M54 TO M6 DCO

Review of land acquisition at Hilton Park

JAC26444
M54 to M6 DCO,
Review of land acquisition at
Hilton Park
Draft
13th August 2020

INITIAL REVIEW OF LAND ACQUISITION

Drawing Title
**FIGURE 6.8
HILTON PARK 1842**

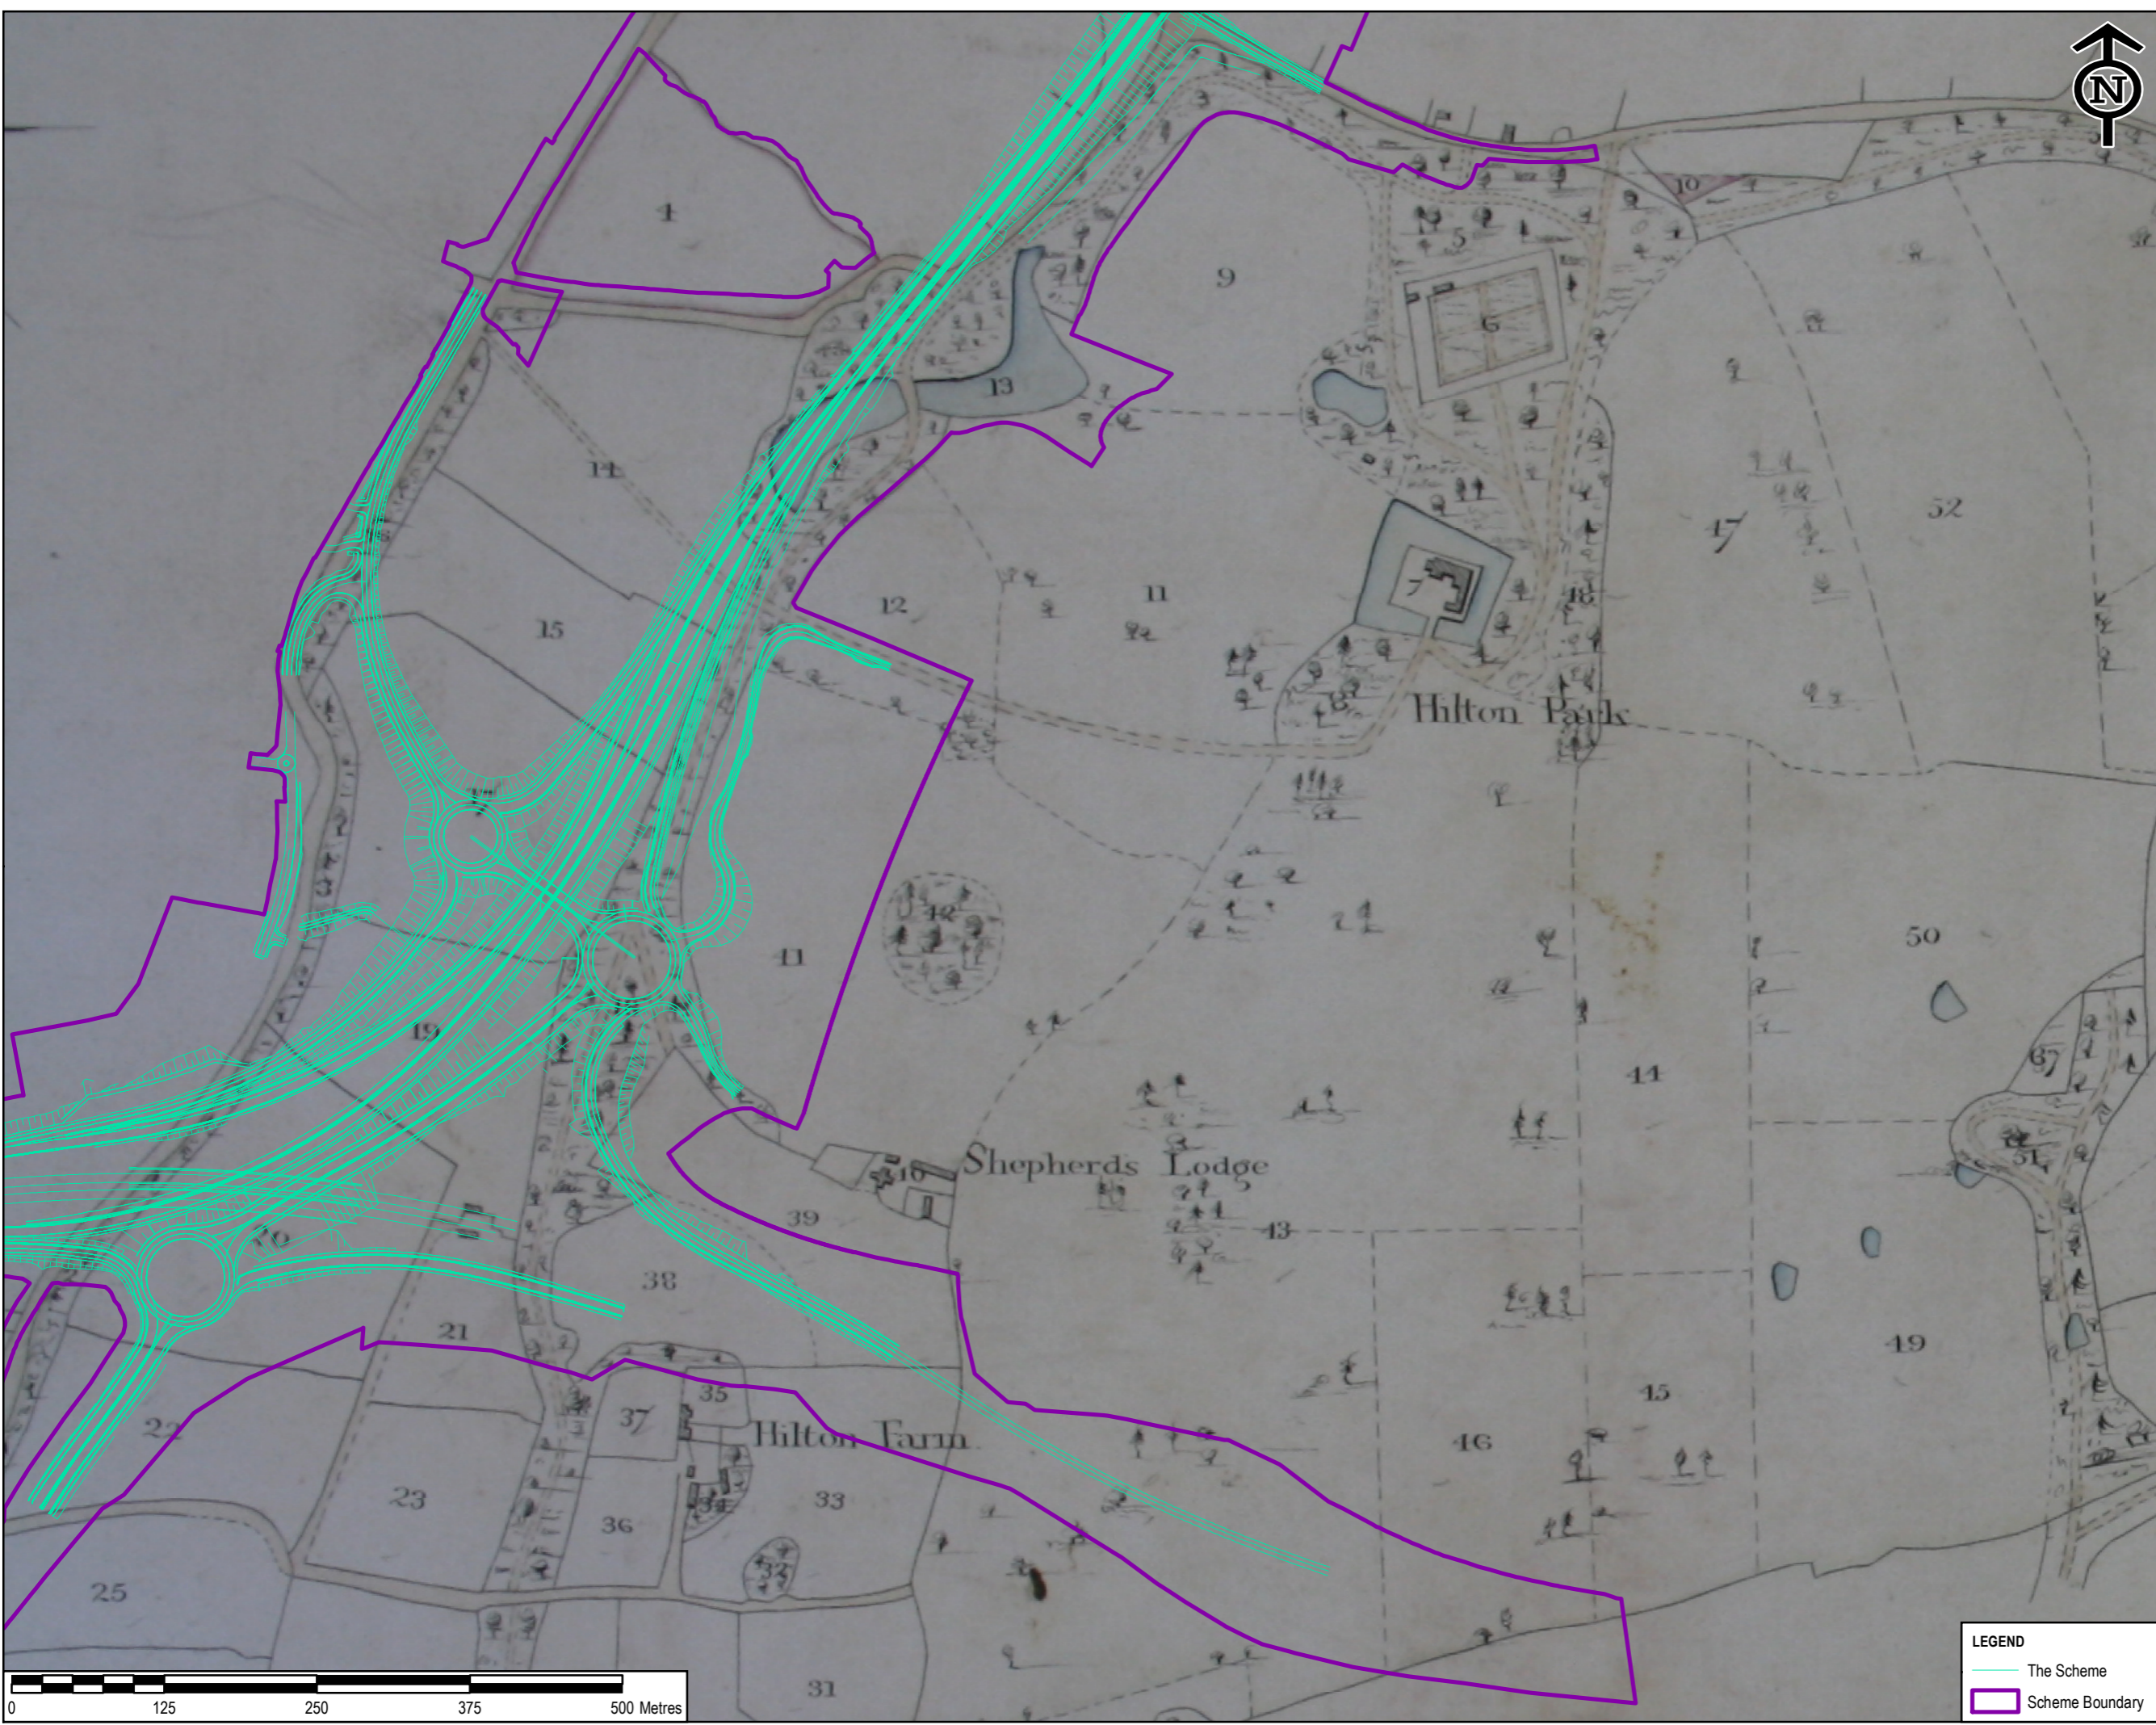
- 2.13 Appendix 6.5 of the ES makes reference to a series of historic maps in order to illustrate the development of Hilton Park, some of which are reproduced as figures within the ES. These include an Estate Map of 1796 (Figure 6.7) and the Tithe Map of 1842 (Figure 6.8). There is no reference in Appendix 6.5 to William Fowler’s Hilton Survey of 1651 or to Robert Dawson’s map of 1816. The latter is the original preliminary drawing for the Ordnance Survey, prepared at a scale of one inch to the mile.

- 2.15 In the assessment of the 20th century development of the park within Appendix 6.5, it is stated that the Lower Pool is *‘first depicted on the 1842 Tithe Map’*. [4.1.1]. This statement is incorrect - the Lower Pool is actually clearly depicted on Robert Dawson’s 1816 map of the area (see Figure 1 of this review for comparison with Figures 6.7 and 6.8 of the ES).
